From:
Sent: 29 August 2026 06:51
To: DC Admin;
Cc: Cllr Anthony Smith
Subject: Final Comment: Revised plans 2 - Planning application 2026/91900

I am submitting a final comment because revised plans were uploaded on the last day of consultation and they materially change the depiction of the access, steps, and boundary. These changes require clarification and do not reflect the physical reality on site.

Client Mr Barrett	
Job 70 Ainley Road Huddersfield	
Title Proposed Floor Plan	
Drawn By RK	Date Feb 2026
Eng. Check	Scale 1:50
Tech. Check	
Drawing No. 2026 / 514 / 02	Rev. 1

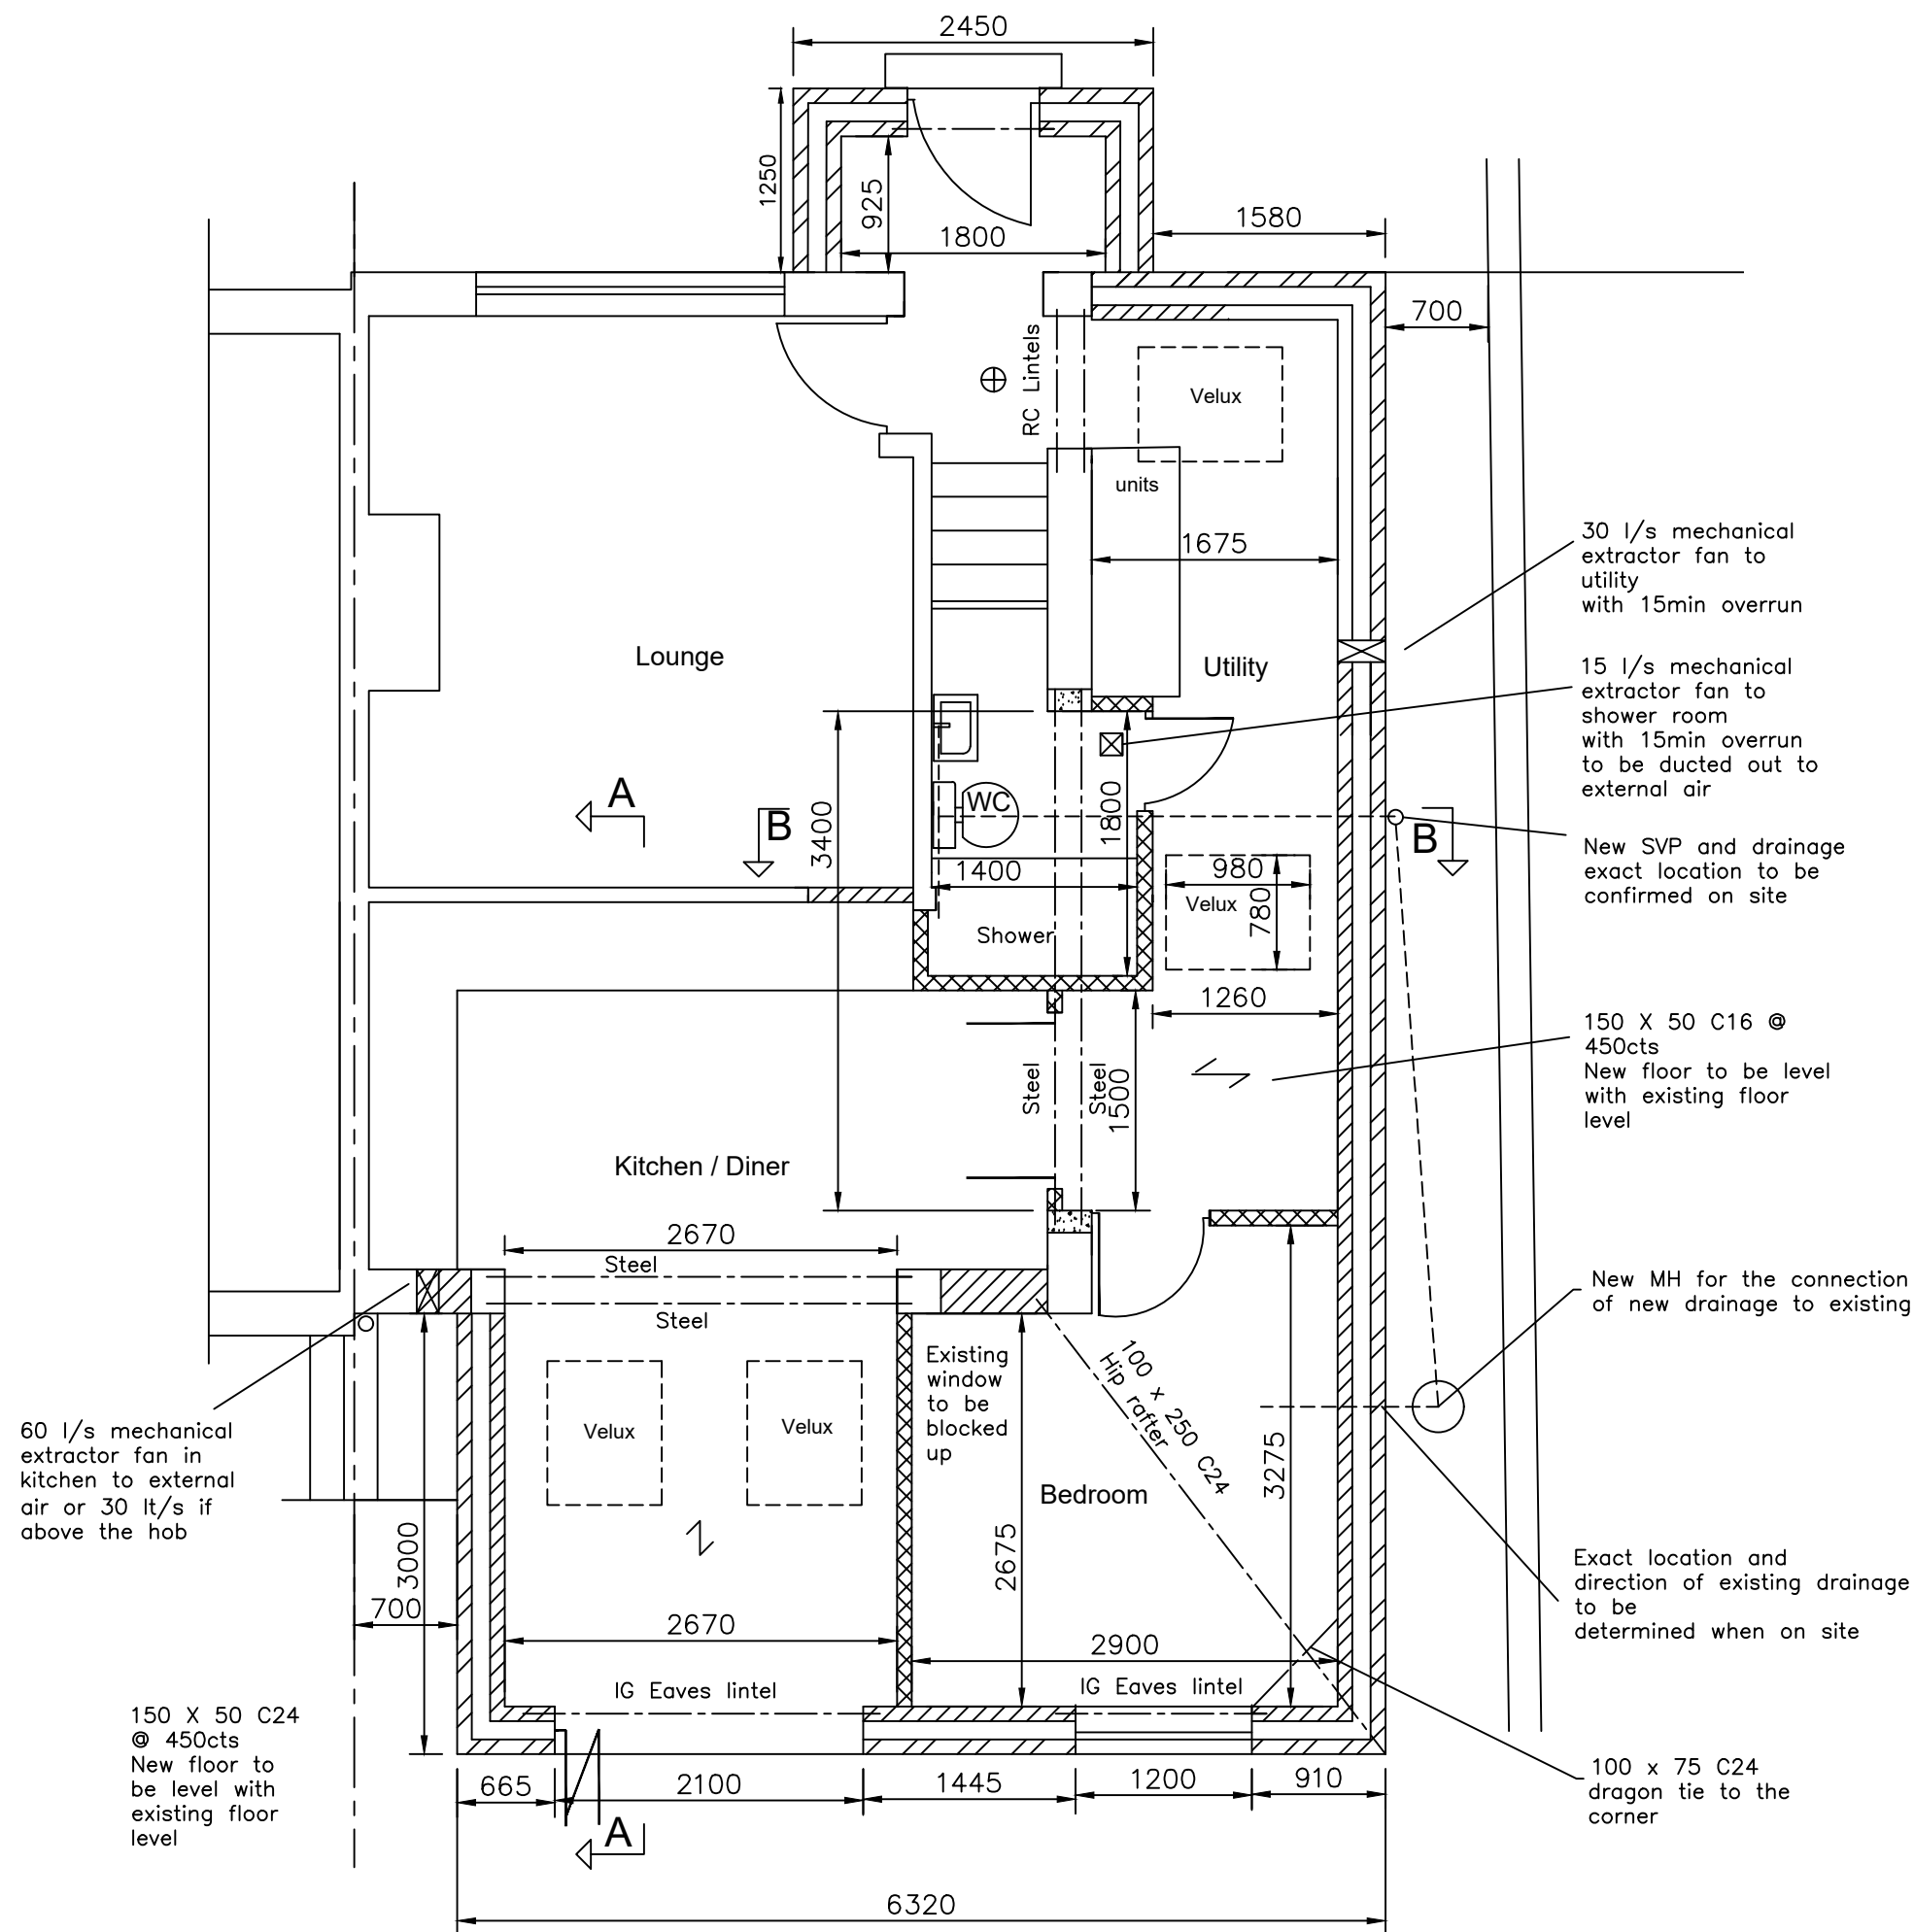
1. Steps and landing area

The newly drawn steps do not match the existing steps on site.
The current steps are straight, uneven, and partially obstructed by a large pipe.

The revised plan shows one step at a right angle, which does not exist and does not reflect the real geometry.

The landing at the top of the steps remains extremely limited and is already below safe access standards.

2. Gate position and swing

The gate is not shown on the revised plan.

In reality, the gate swings towards the steps and already strikes the boundary fence.

Any reduction in usable space would place the gate arc inside the proposed wall position, creating a collision hazard and further restricting access.

3. Usable width and the “90 cm gap”

Although the new plan shows a 90 cm gap between the proposed wall and the boundary line, the actual usable width remains significantly less due to:

The physical width at the landing is approximately 30–45 cm and cannot be increased by redrawing the steps.

The revised plan does not represent the real constraints on site.

The revised drawings still omit:

and the true step geometry.

It is also worth noting that the extractor fan has remained in the same place which would be another issue when turning such a narrow gap.

Proposed Site Plan

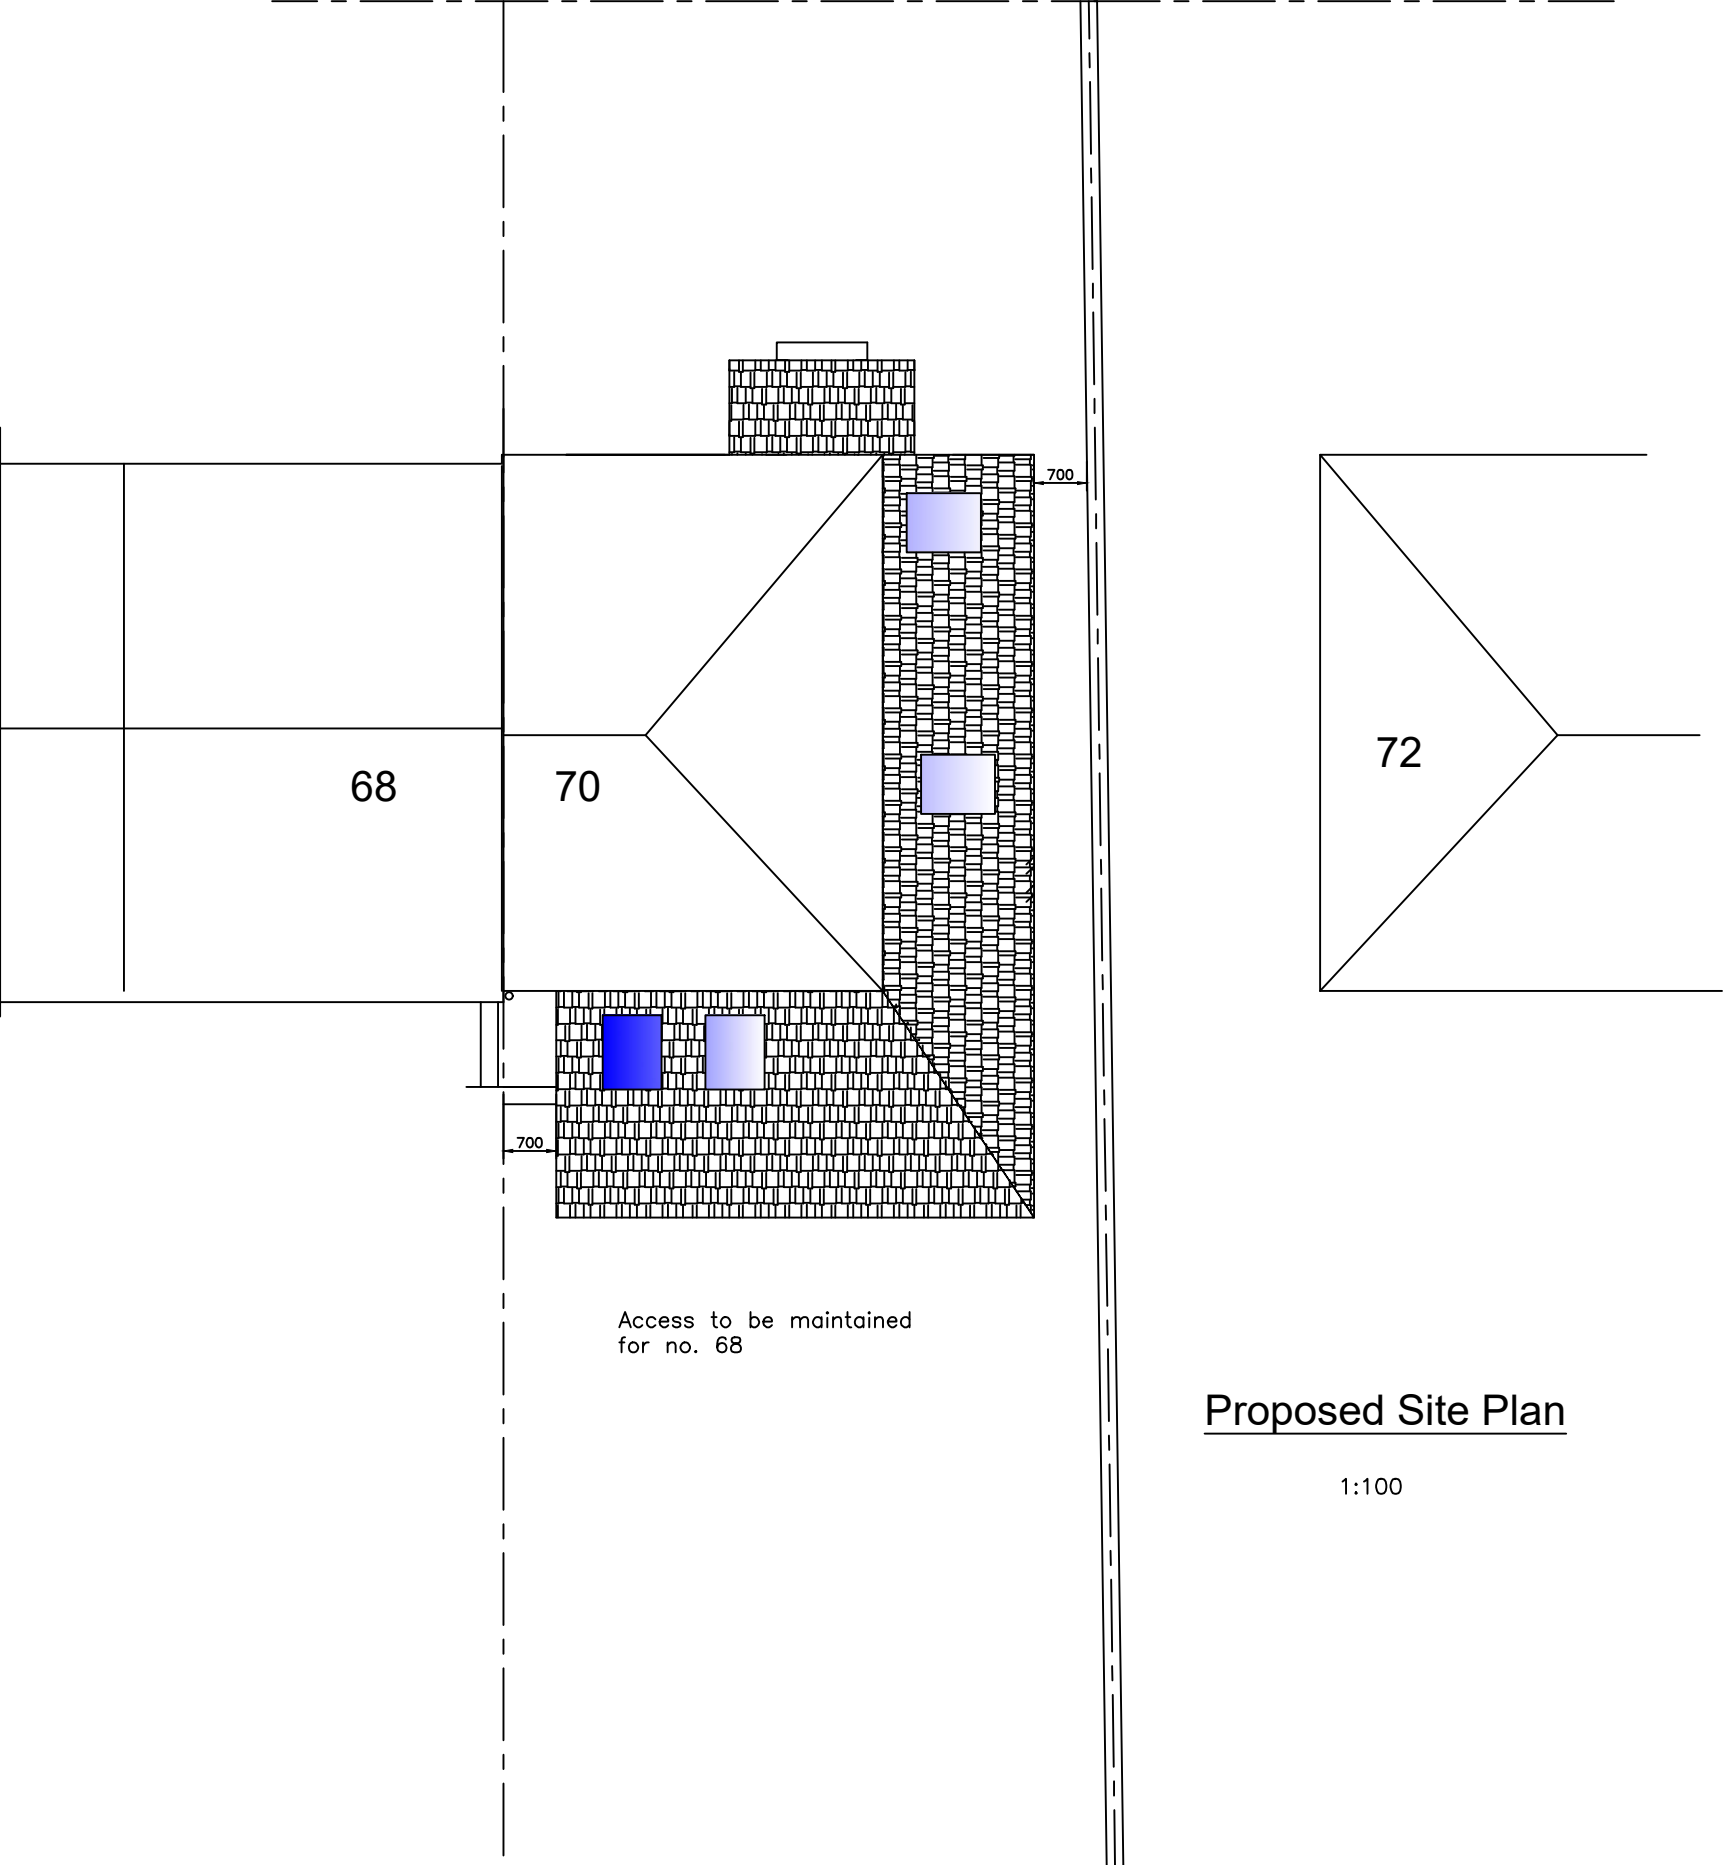
4. Pipe obstruction

The large pipe on the opposite side of the access continues to obstruct the walking line and reduce usable width.

These omissions mean the plans do not accurately represent the site and do not allow a safe assessment of access or amenity impact.
